BEFORE THE HEARING EXAMINER OF THE CITY OF MERCER ISLAND

IN RE: NOTICE OF DECISION: FILE NO.
2207-019

Case No. APL24-002

APPELLANT DANIEL GROVE'S PRE-
HEARING MEMORANDUM AND
RESPONSE TO DOROTHY STRAND
AND THE CITY OF MERCER
ISLAND'S REQUEST FOR
DISMISSAL

SOUTH ELEVATION

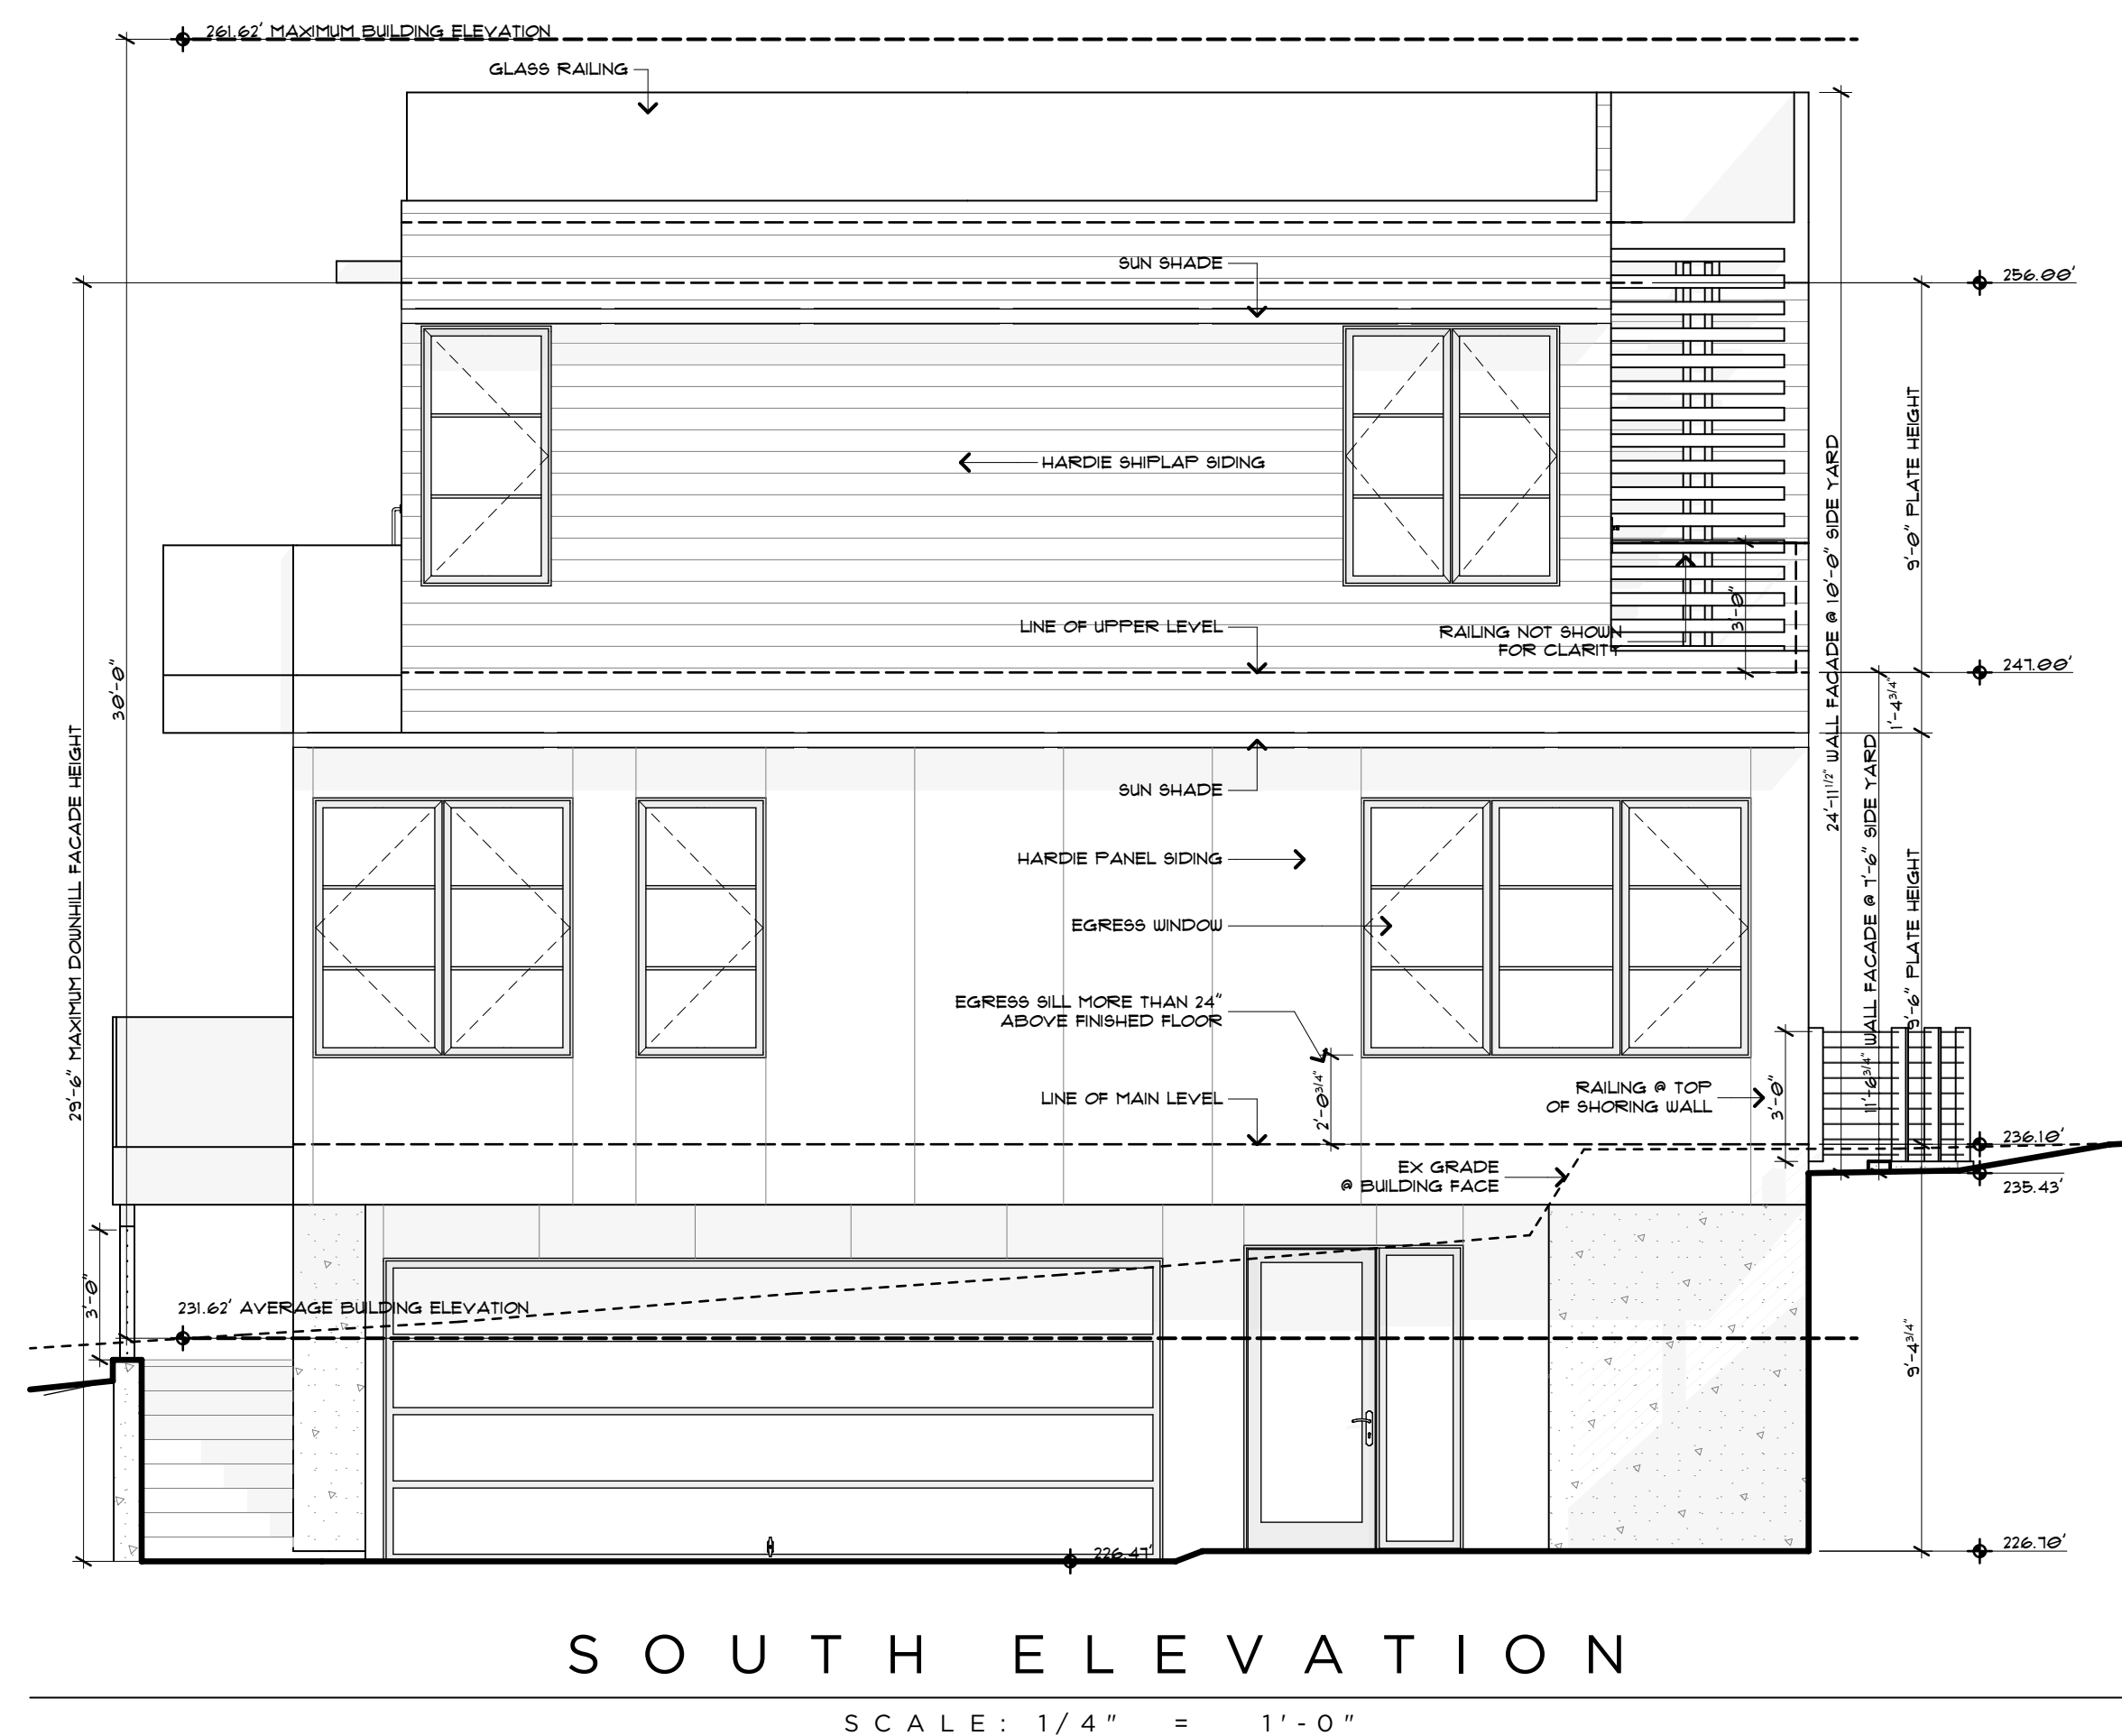
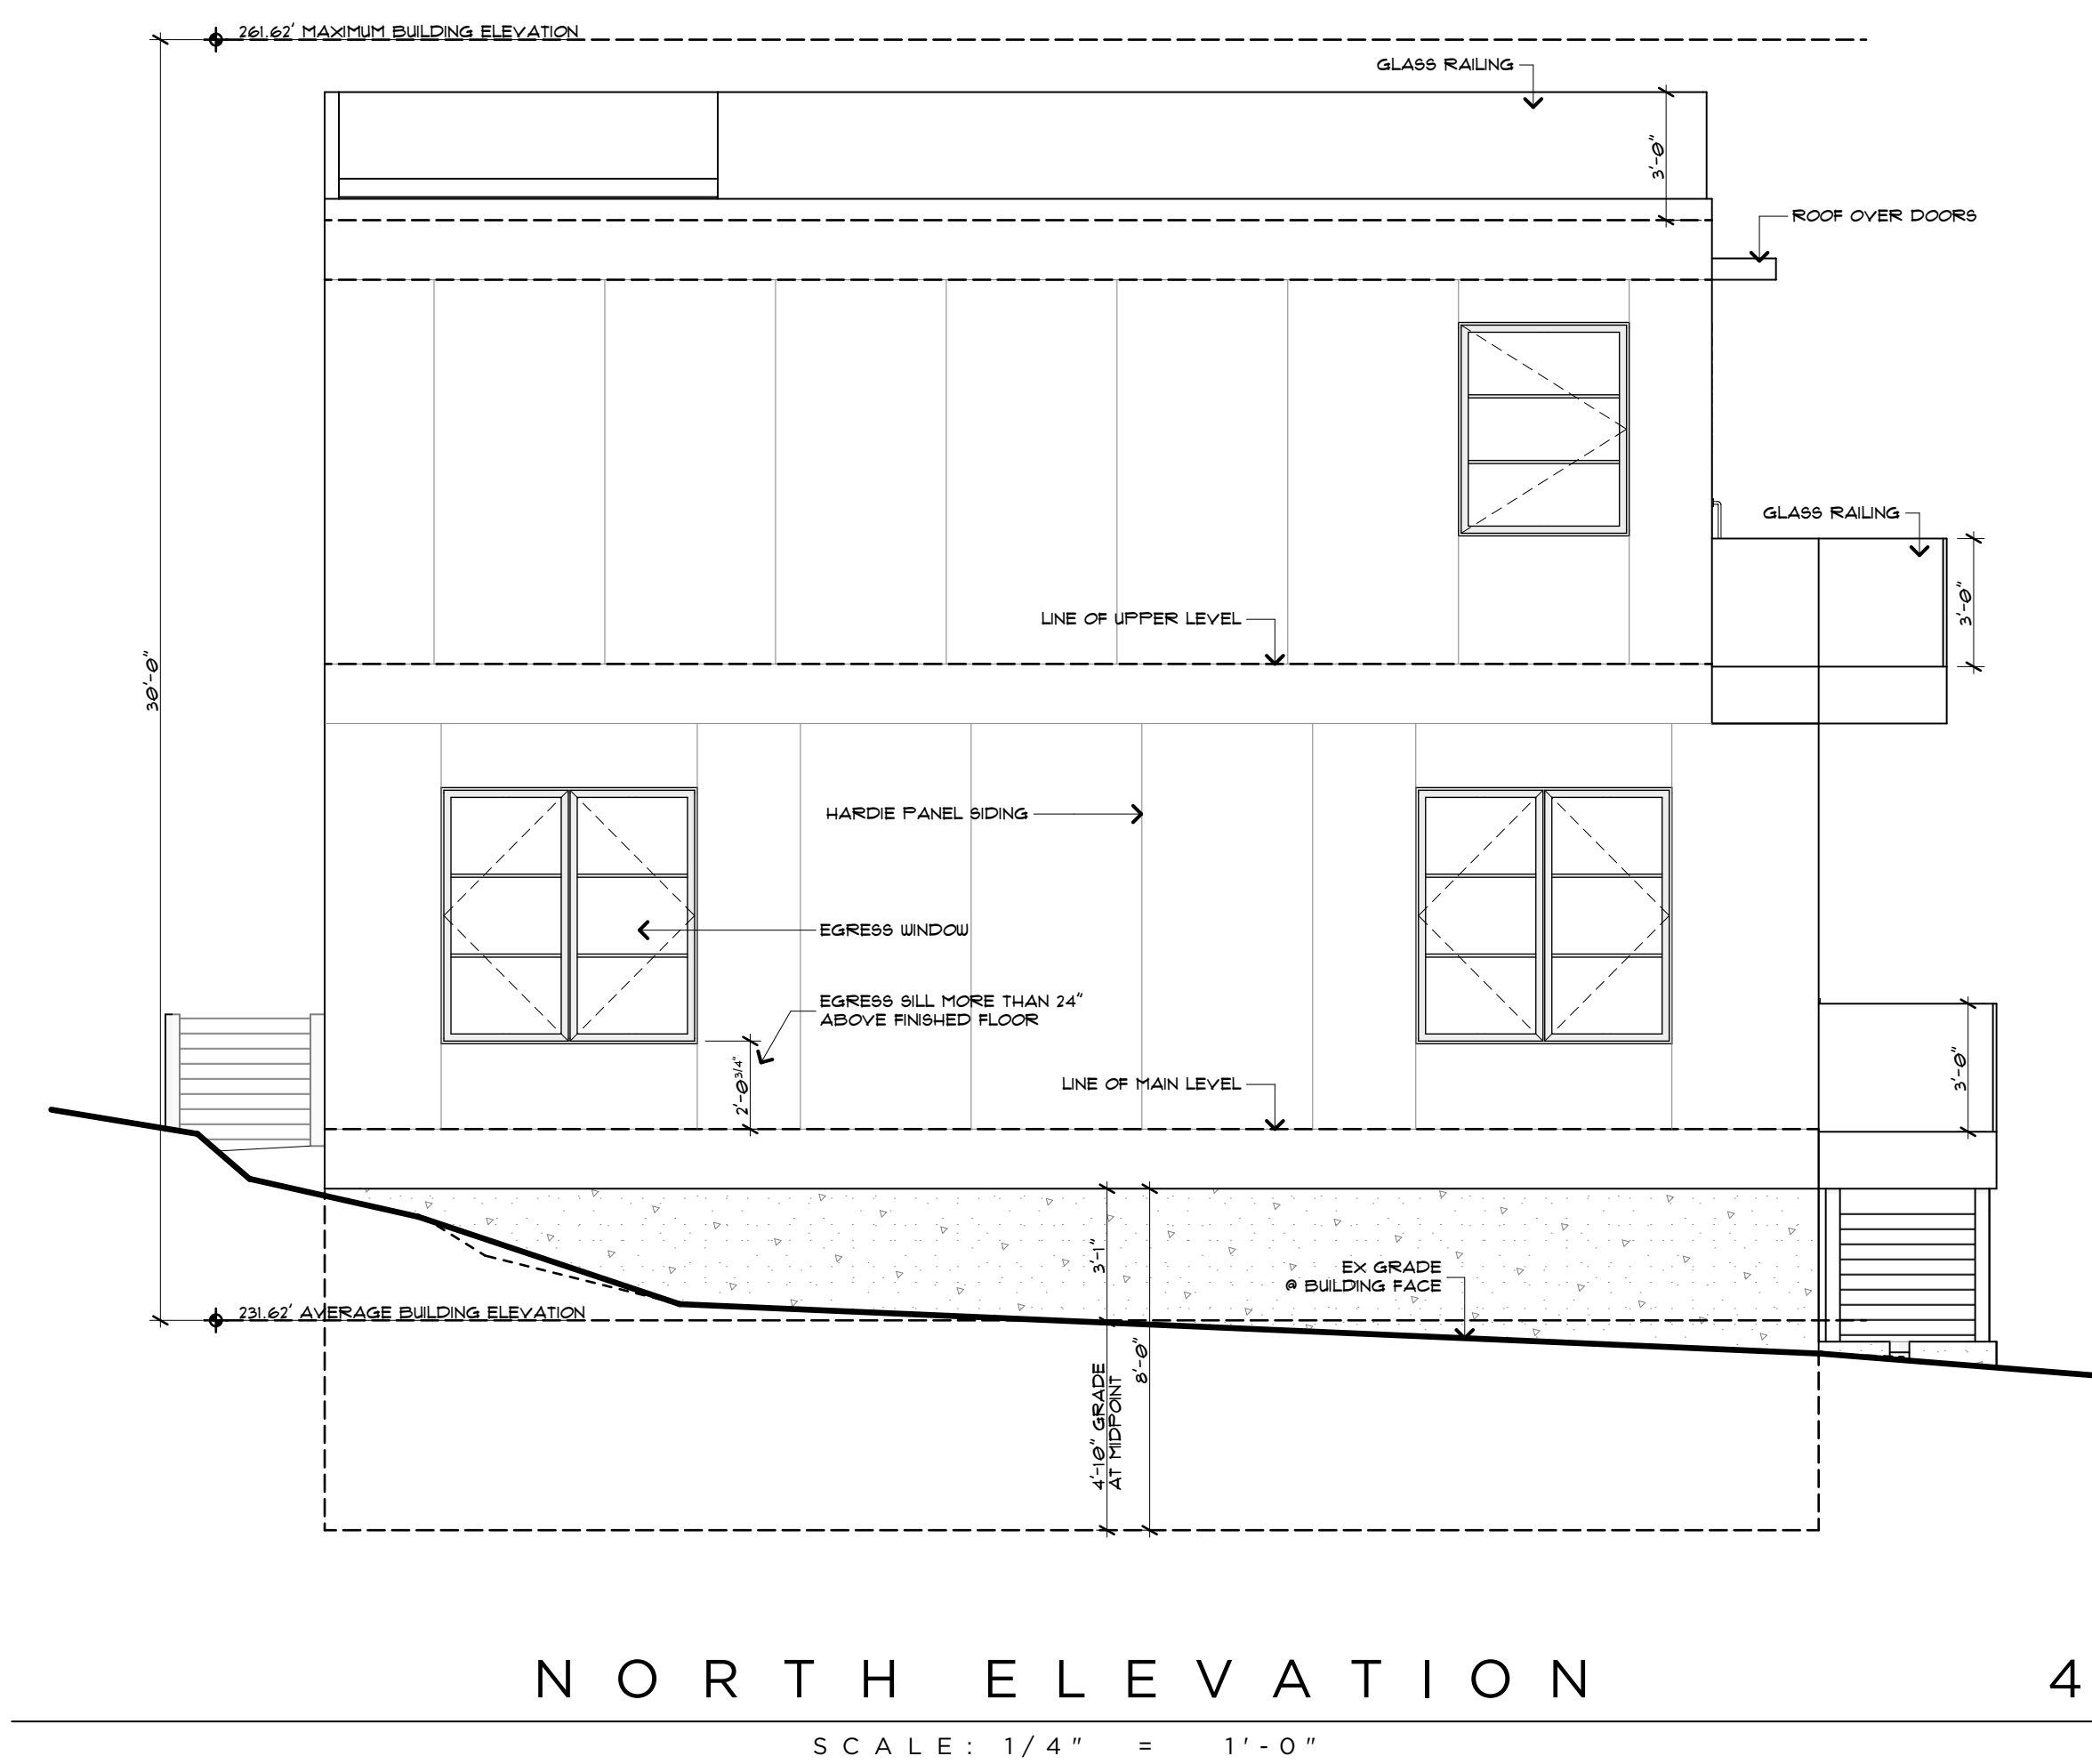
15 **D. The home’s rooftop railings on the southern side to exceed maximum height limits**
16 **set by the code**

17 The City and Ms. Strand’s interpretation of the code related to rooftop railings in this case
18 is simply inconsistent with a plain reading of the applicable code provisions. As the City
19 acknowledges, pursuant to MICC 19.02.020(E)(2):

1 *whichever is lower, at the furthest downhill extent of the proposed*
2 *building*, to the top of the exterior wall facade supporting the roof
3 framing, rafters, trusses, etc.” Staff Report at 8. It is not disputed
4 that the property at issue in this case slopes downhill primarily from
5 east to west. The rooftop railings attached to the southern exterior
6 wall and the southern end of the western wall both exceed maximum
7 allowed heights.

8 Certain appurtenances may exceed that 30-foot height limit, but rooftop railings are not
9 one of them. MICC 19.02.020(E)(3)(b). *Id.* Ms. Strand appears to rely on a measurement from the
10 “Average Building Elevation” to determine a height of below 30 feet. *See* Strand Motion at 8. But
11 this is not consistent with the language of MICC 19.02.020.E., as explained above. The City
12 appears to rely on Ms. Strand’s inaccurate calculations to come to a similar conclusion that the
13 height has not been exceeded. Mr. Grove requests the Hearing Examiner review these
14 determinations and remand to the City for further consideration.
